Addendum to the Biodiversity Assessment Report

90 Gindurra Road, Somersby NSW 2250

State Significant Development Application (SSD 8660)

21st December 2020

Figure 4. Groundwater Dependent Ecosystems as provided by the GDE Atlas on 23<sup>rd</sup> October 2018. Subject Site indicated by Red point.

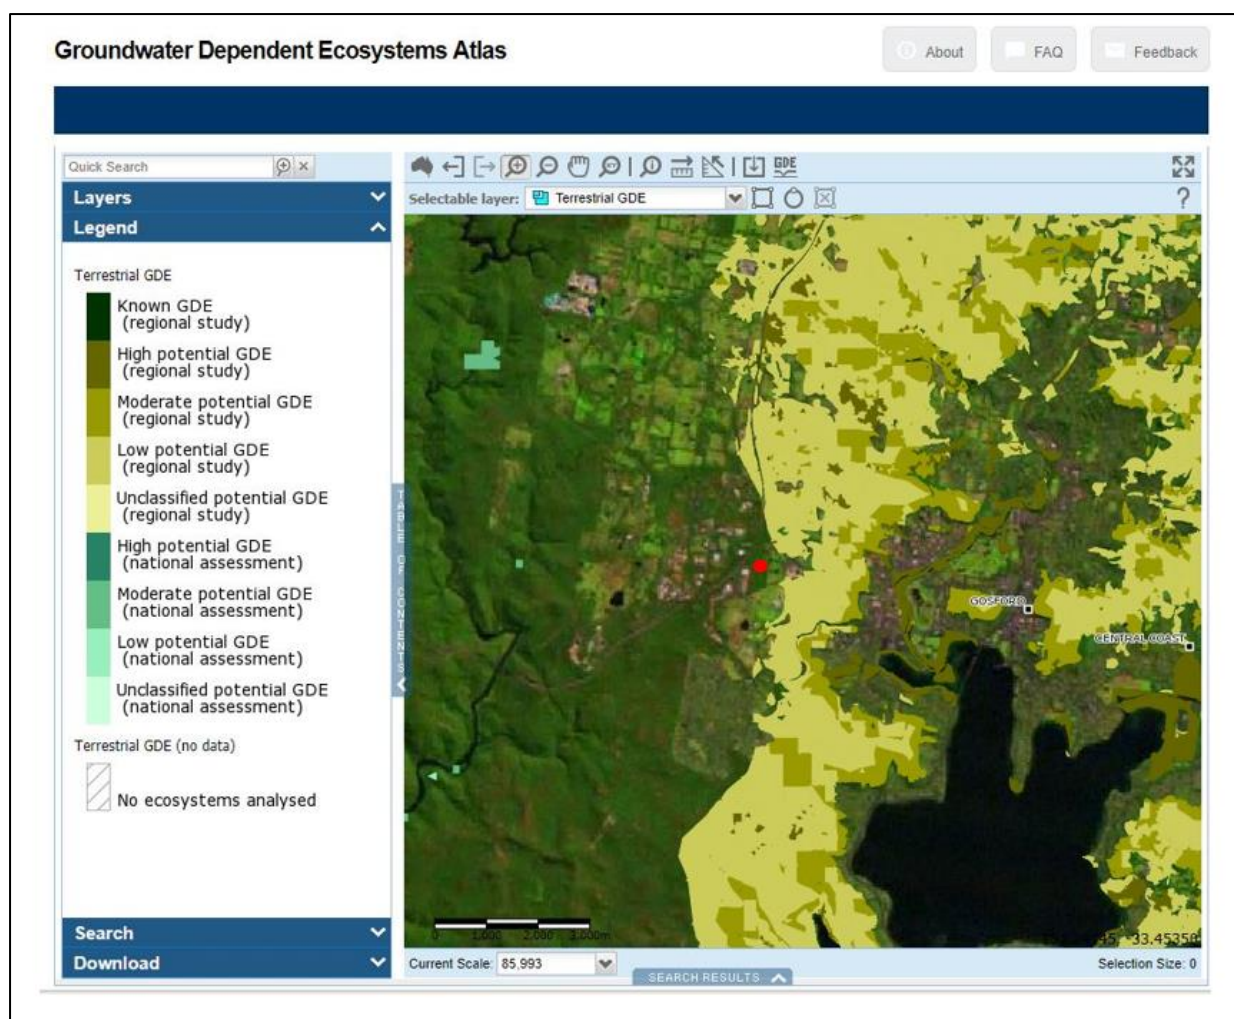
"The Biodiversity Assessment Report states that "The Narla Ecologists did not find any vegetation communities or other ecosystems that would meet the definition of GDE during the site assessment", but it is not stated whether these surveys included the southern vegetated section of the property or any adjoining properties. Clarification is required".

Narla Environmental accessed the GDE Atlas on 23rd October 2018 which revealed that there are no GDEs within the Subject Site. The Narla Ecologists did not find any vegetation communities or other ecosystems that would meet the definition of GDE during the site assessment (Narla Environmental 2019).

Surveys for GDEs were conducted across the entire Subject Site. The southern vegetated section of the property was not assessed for GDEs. In addition, no adjoining properties were assessed.

**Figure 8. Targeted survey for threatened plants within the Subject Property (16<sup>th</sup> January 2018, 14<sup>th</sup> February 2018, 10<sup>th</sup> April 2018, 21<sup>st</sup> August 2018, 20<sup>th</sup> September 2019, 15<sup>th</sup> October 2019 and 1<sup>st</sup> November 2019)**

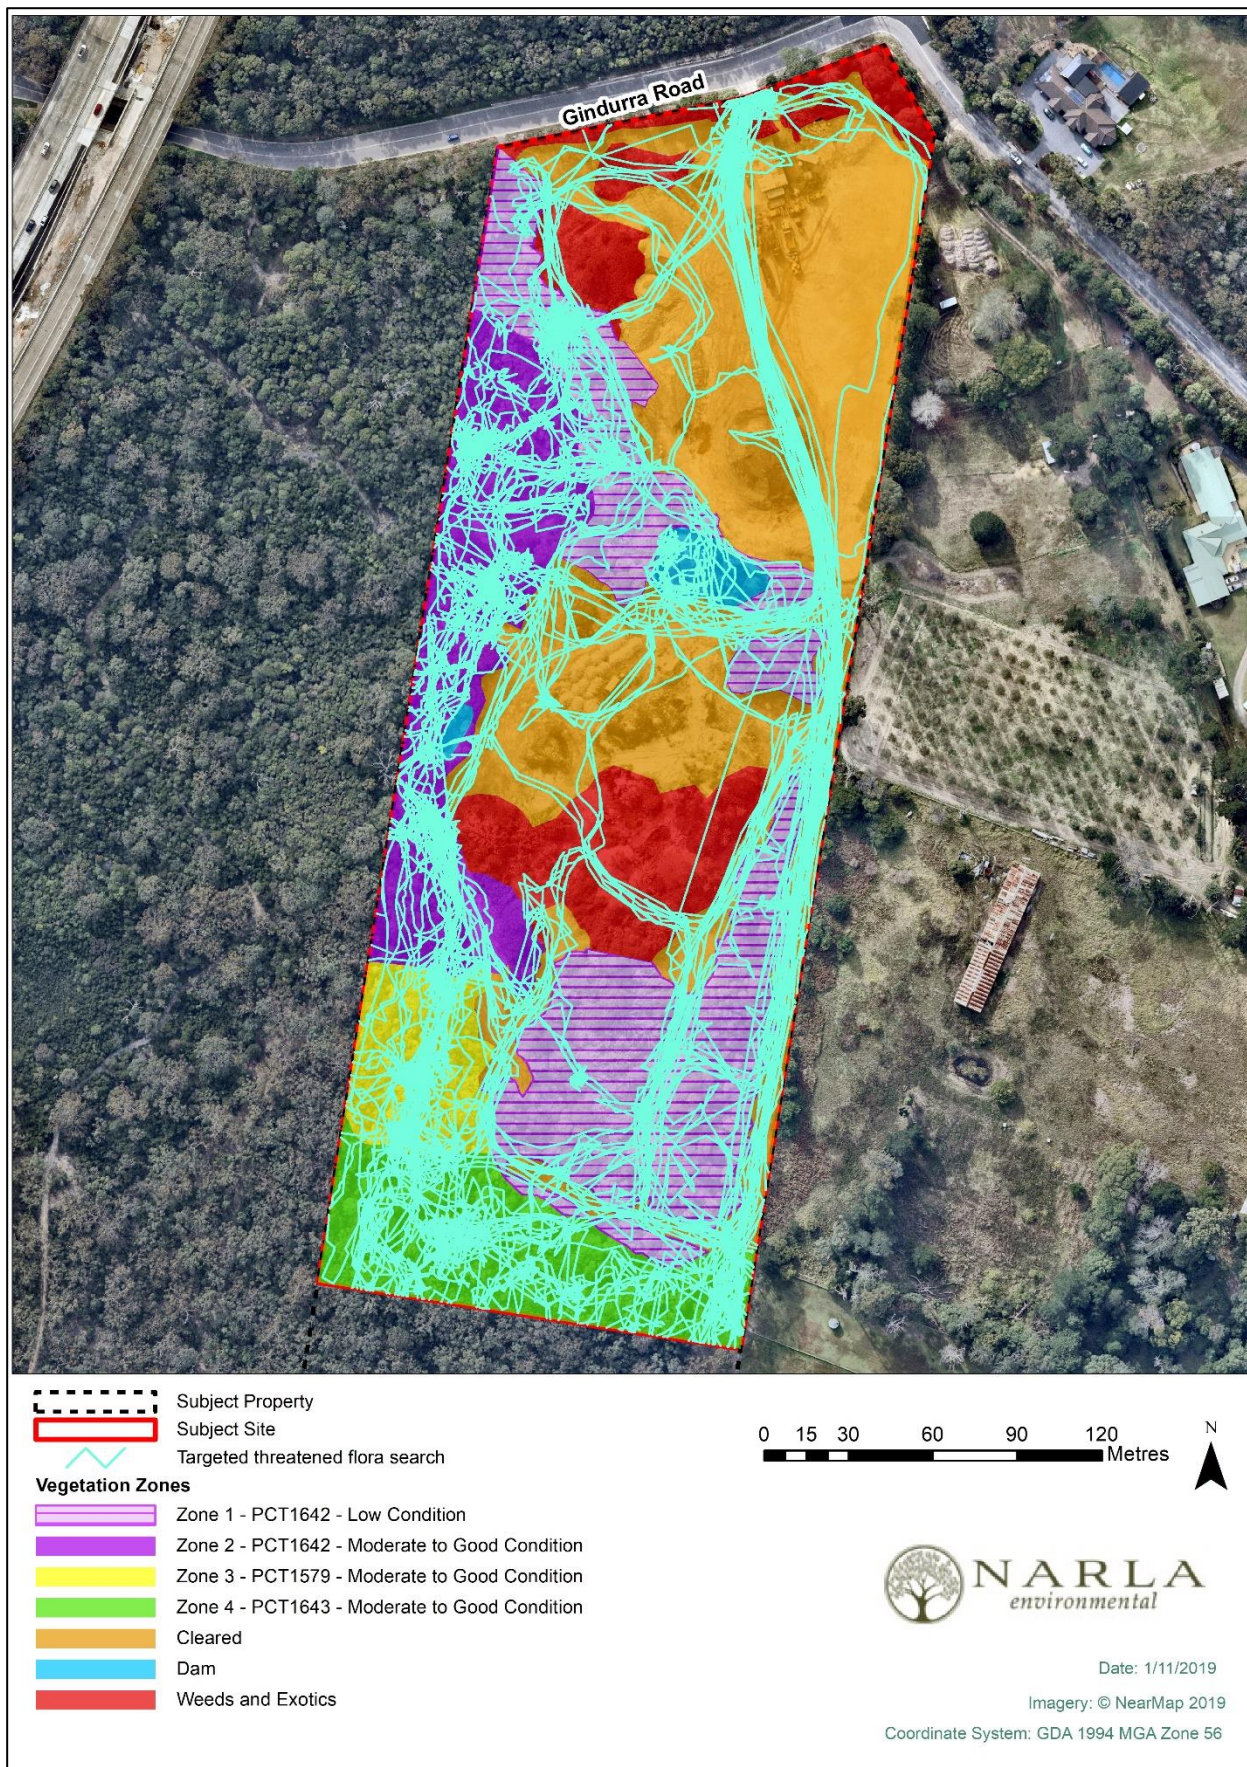
“The purchase of *Prostanthera junonis* species credits is not included in the report. The 2020 DPIE “Surveying threatened plants and their habitats - NSW survey guide for the Biodiversity Assessment Method” includes the following recommendation on assuming presence of *Prostanthera junonis* on long undisturbed sites:

“Assuming species presence or the use of an expert report is recommended for some species, such as disturbance specialists, where site history indicates a long time since the required disturbance events. For example, *Prostanthera junonis* (Somersby mintbush) was rediscovered after 67 years on the Central Coast of New South Wales following soil disturbance associated with land clearing (Tierney & Gross 2001).

This species is now known to occur as a post-fire coloniser that eventually disappears from the above ground biomass as associated vegetation thickens and shades it out.” pp 20.

In the case of the current application, surveys have been undertaken but no expert report has been provided. Considering the above, calculation of applicable species credits OR provision of an expert report OR further discussion as to why presence within the development area has not been assumed is required, particularly given the known occurrence in the southern part of the property”.

Targeted surveys were undertaken for *Prostanthera junonis* (Somersby Mintbush) across the Subject site on 20th September 2019, 15th October 2019 and 1st November 2019. Narla Environmental contacted DPIE (formerly OEH) for the location of a suitable, proximal reference site for *Prostanthera junonis* in order to ensure that a local population of the species is in flower at the time of survey. In addition, it was important to understand the habitat requirements of the species for reference to the Subject Site. A reference population was provided by DPIE which is located at the end of Little Mooney Creek Road, Somersby, in Brisbane Water National Park. This reference population was visited immediately prior to the surveys on 20th September 2019, 15th October 2019 and 1st November 2019.

The reference population was in full flower when visited on 20th September 2019 and 15th October 2019. Flowering had significantly declined when visited on 1st November, although a number of flowers continued to remain on the plant. No *Prostanthera junonis* were observed in the Subject Site by Narla Environmental.

As discussed above, Narla undertook extensive targeted surveys for *Prostanthera junonis* in the appropriate survey period (DPIE 2020). The results of the targeted surveys are included on Page 63 of the BAR (Narla Environmental 2019), which outline that no *Prostanthera junonis* were located within the Subject Site. If *Prostanthera junonis* had been in the Subject Site, the Narla Ecologists would have identified individual plants as the nearby reference population was in flower at the time. Narla Environmental followed all possible guidelines and recommendations for the targeted survey of this species.

As such, it is Narla's conclusion that the species was sufficiently surveyed for and no further surveys, expert reports or offset credits should be required. Sufficient detail is provided in the FBAR.
